Please find attached a copy of TII observations on the above proposed Electricity Development Application.

Ár dTag | Our Ref.
TII26-135779

Re: Application for development of a 10 year planning permission for a 110kV grid connection to the national grid at the existing 110kV Moneypoint Substation at Cahermurphy, Cloonwhite South, Sheeaun, Leitrim, Cloonreddan, Kilmacduane East, Clooncullin, Lissanair, Teernagloghane, Brisla East and West, Gowerhass, Tullagower and others, County Clare

ACP case ref. VA03.324156

SHEET NUMBER
05935-DR-202

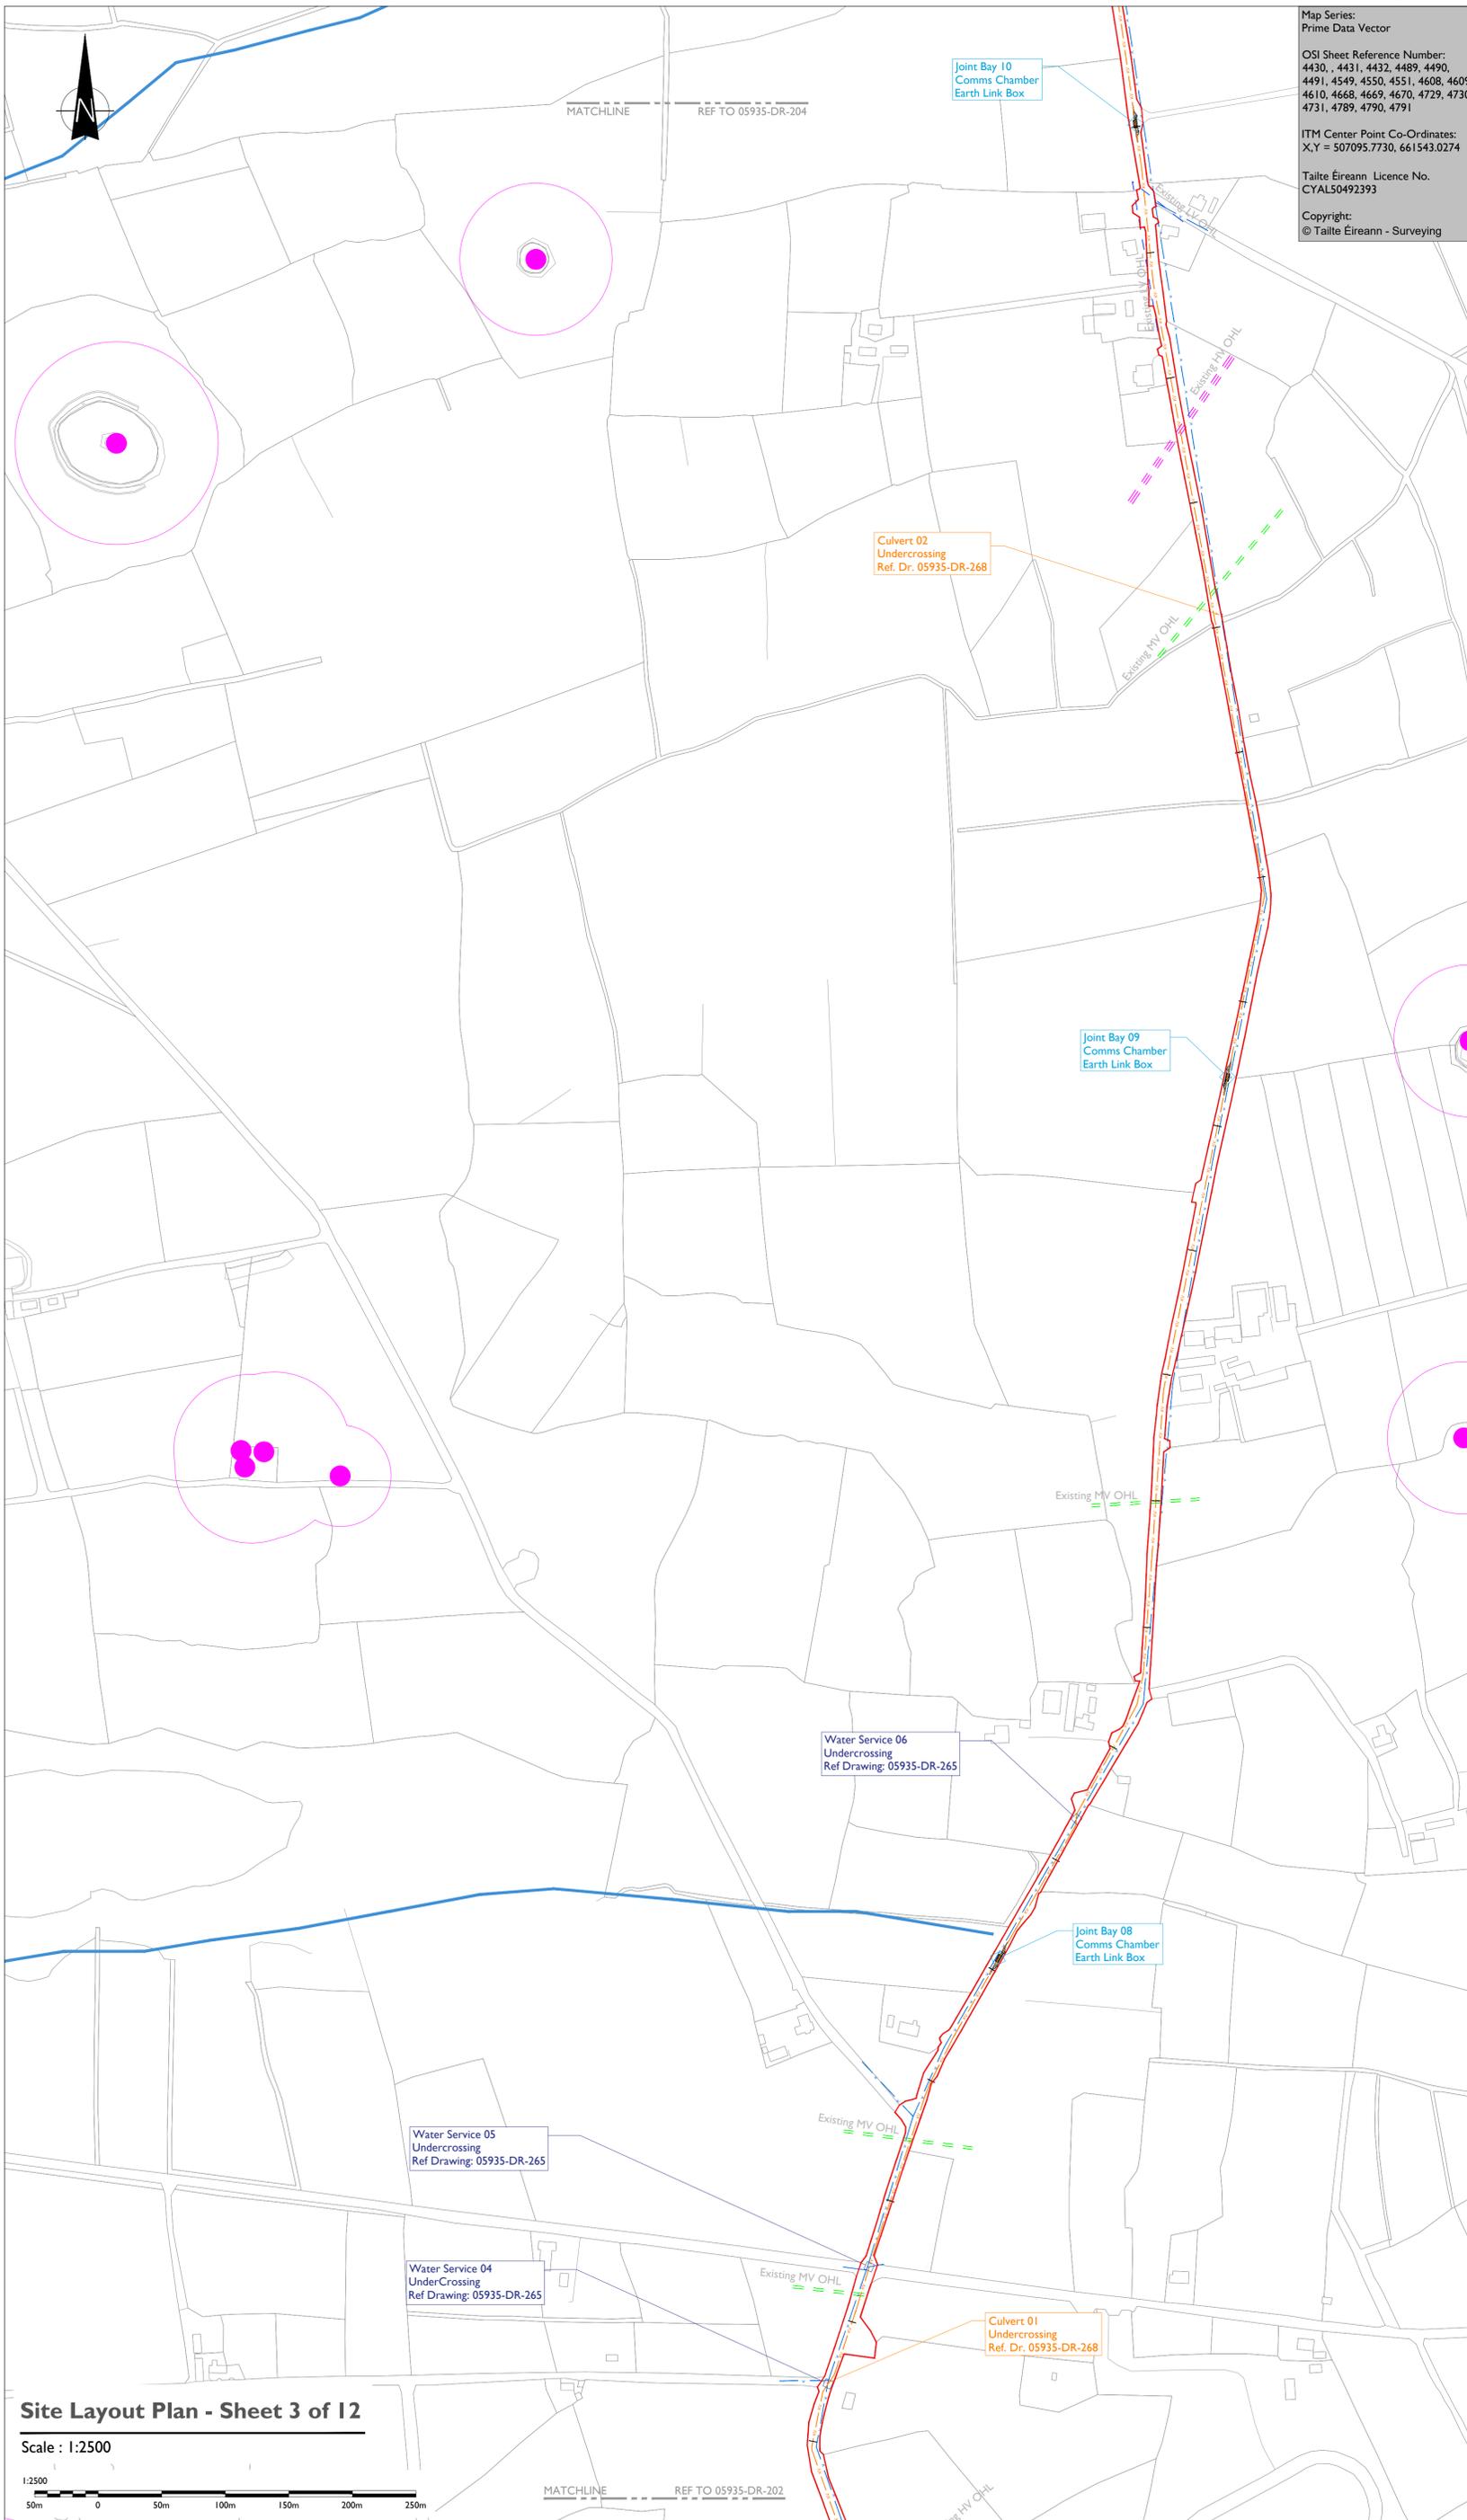
- One crossing of the N68, indicated on Drawing no. 05935-DR-205 as being by HDD,
- One crossing of the N67 indicated on Drawing no. 05935-DR-202 and Appendix 4-4 as not being by HDD,

'Crossings of the N67 and N68 national road network shall be by HDD only. All standards for grid connection cable construction and associated infrastructure in the public road shall be agreed with the Road Authority prior to the commencement of any development.'
